Comment made reference ExQ2

Land Use and Agriculture (LU) section LU.2.01 - Depth of cable

DRAWING NUMBER: 1.4

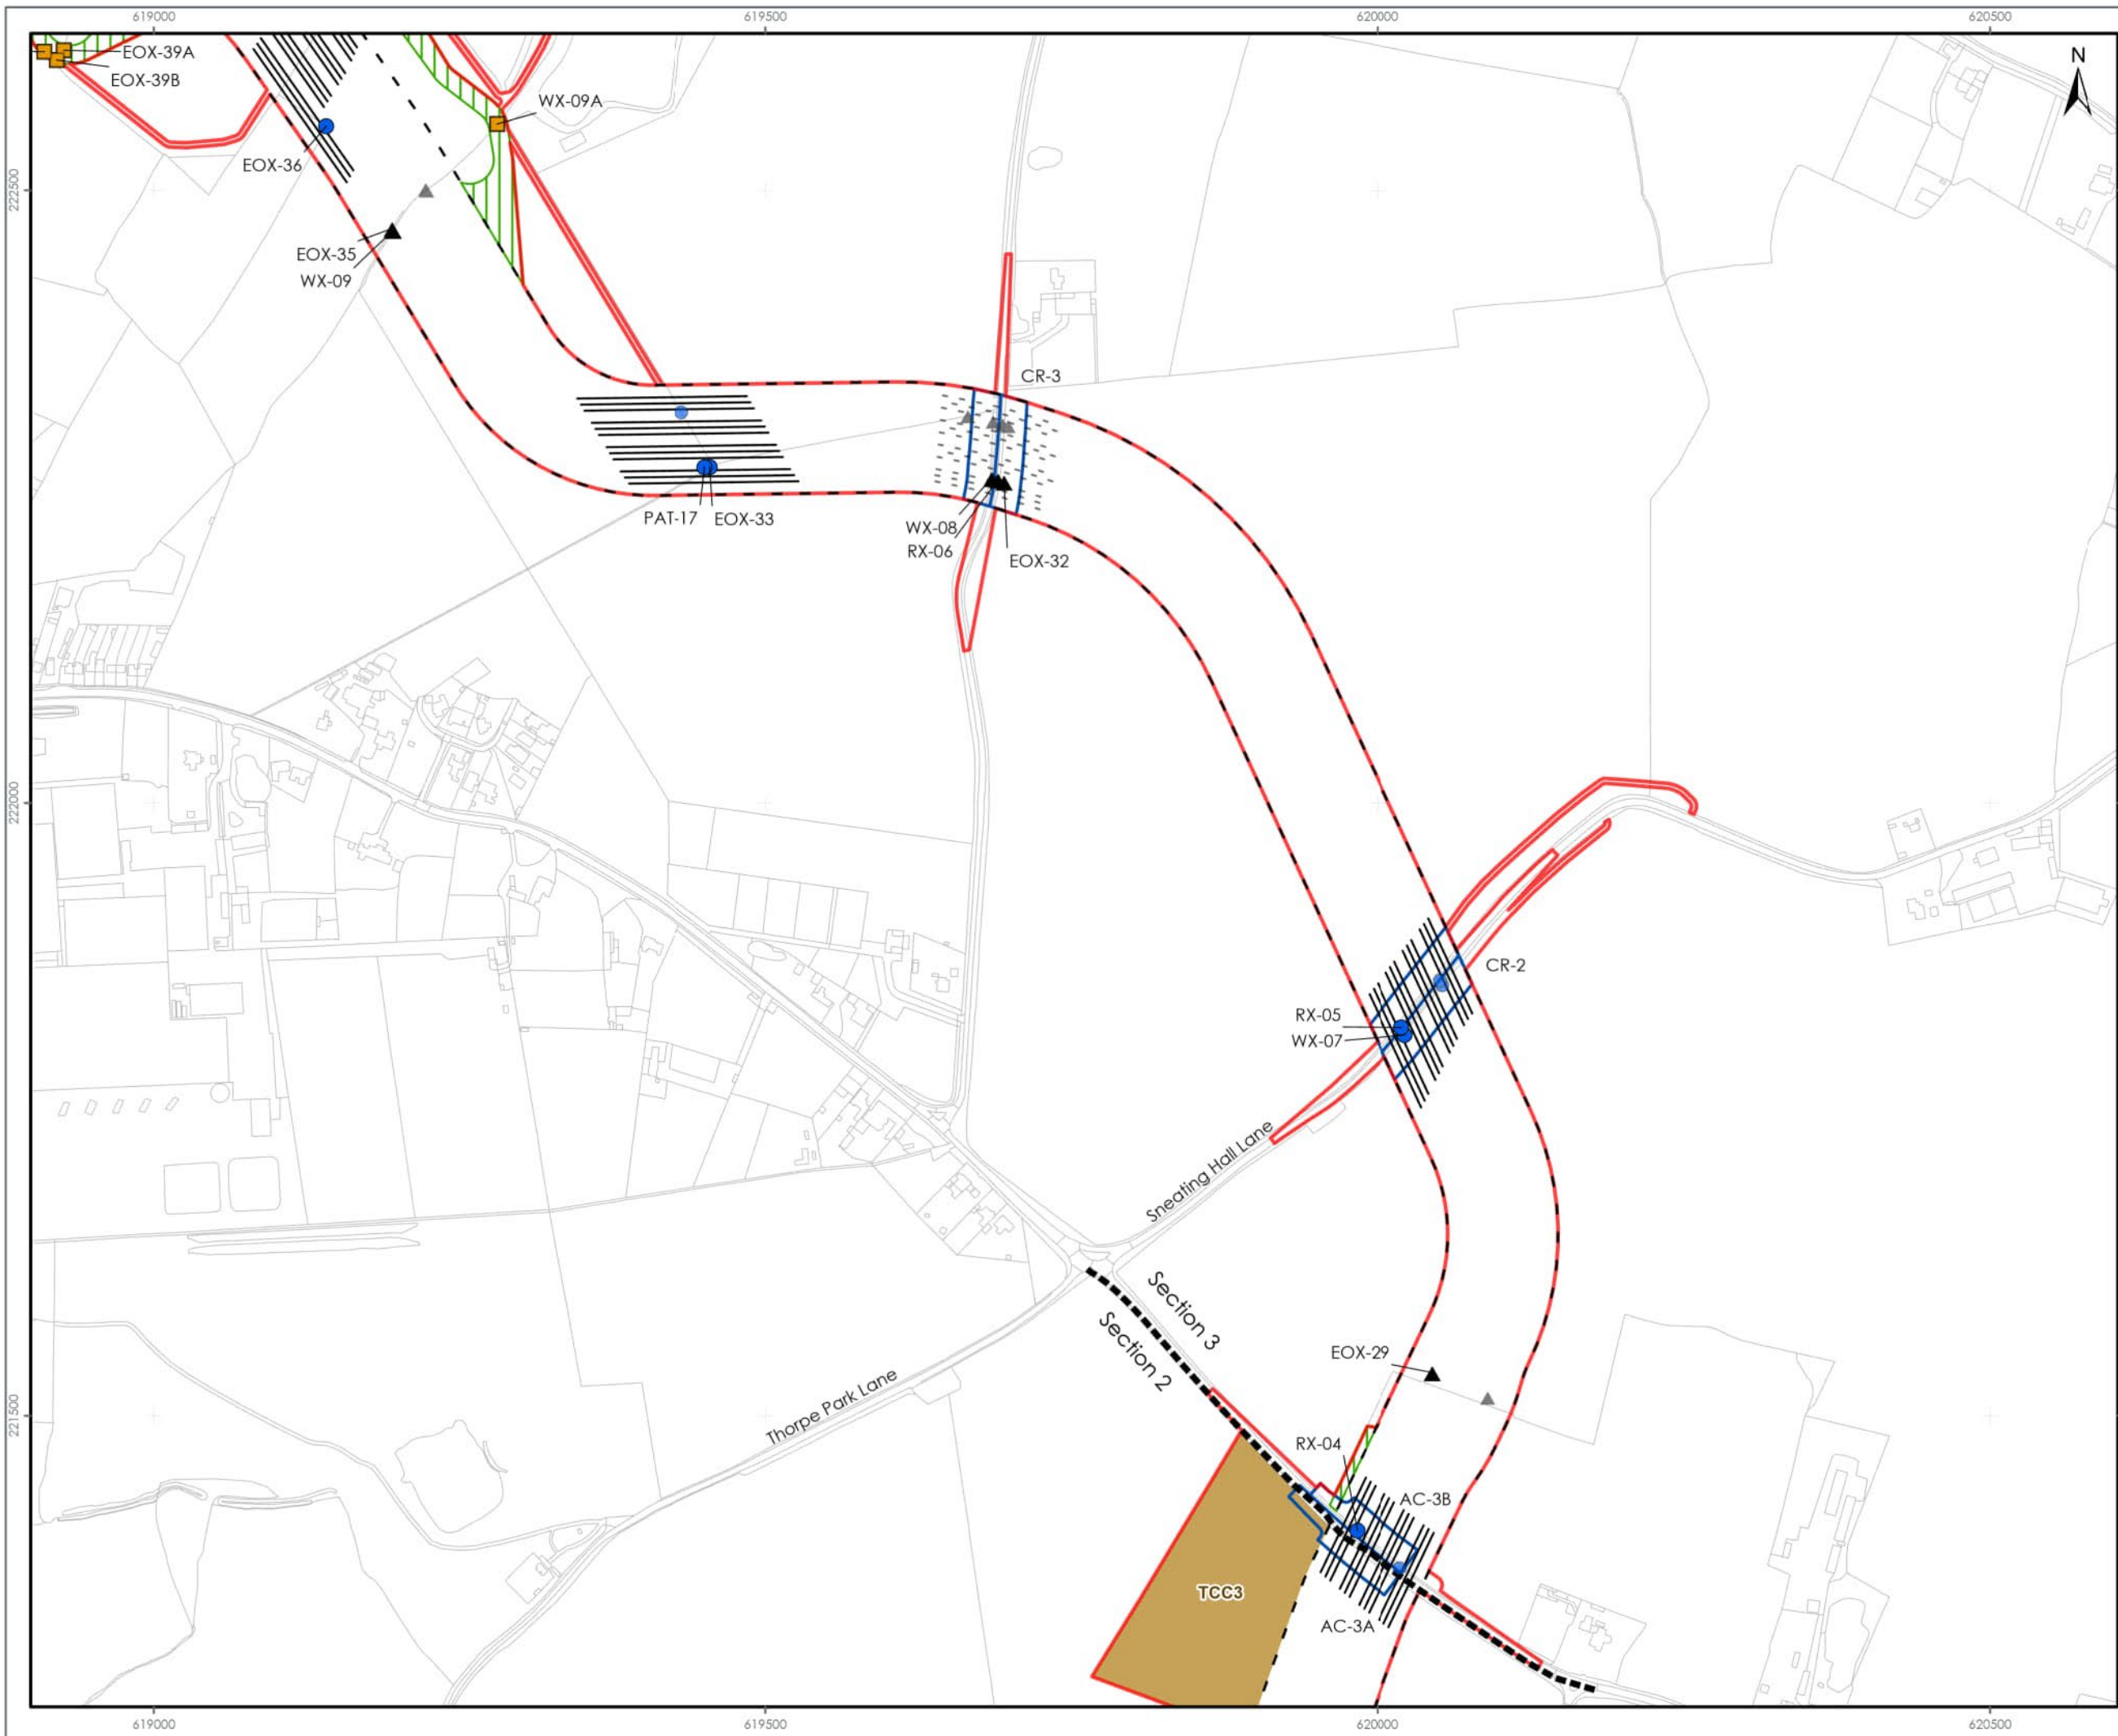
As the land owner and farmer of the second section the cable route crosses post landfall at Frinton on Sea we have serious concerns with the projects proposed minimum cable cover of only 0.9m. The route will disrupt around 28 hectares (69 acres) of land.

Our land drainage schemes run to 1m cover and these require regular maintenance by means of a digger and then hand digging. If the cables were to be at 0.9m cover it would represent a real and serious risk to safety.

We also have a network of underground irrigation mains that are either above our land drains or below, depending on the topography of the land. This means some of these are at or around 1m cover. The cable must be below this depth to ensure safety for us, our staff or any contractors we use to maintain both the drainage systems and irrigation mains.
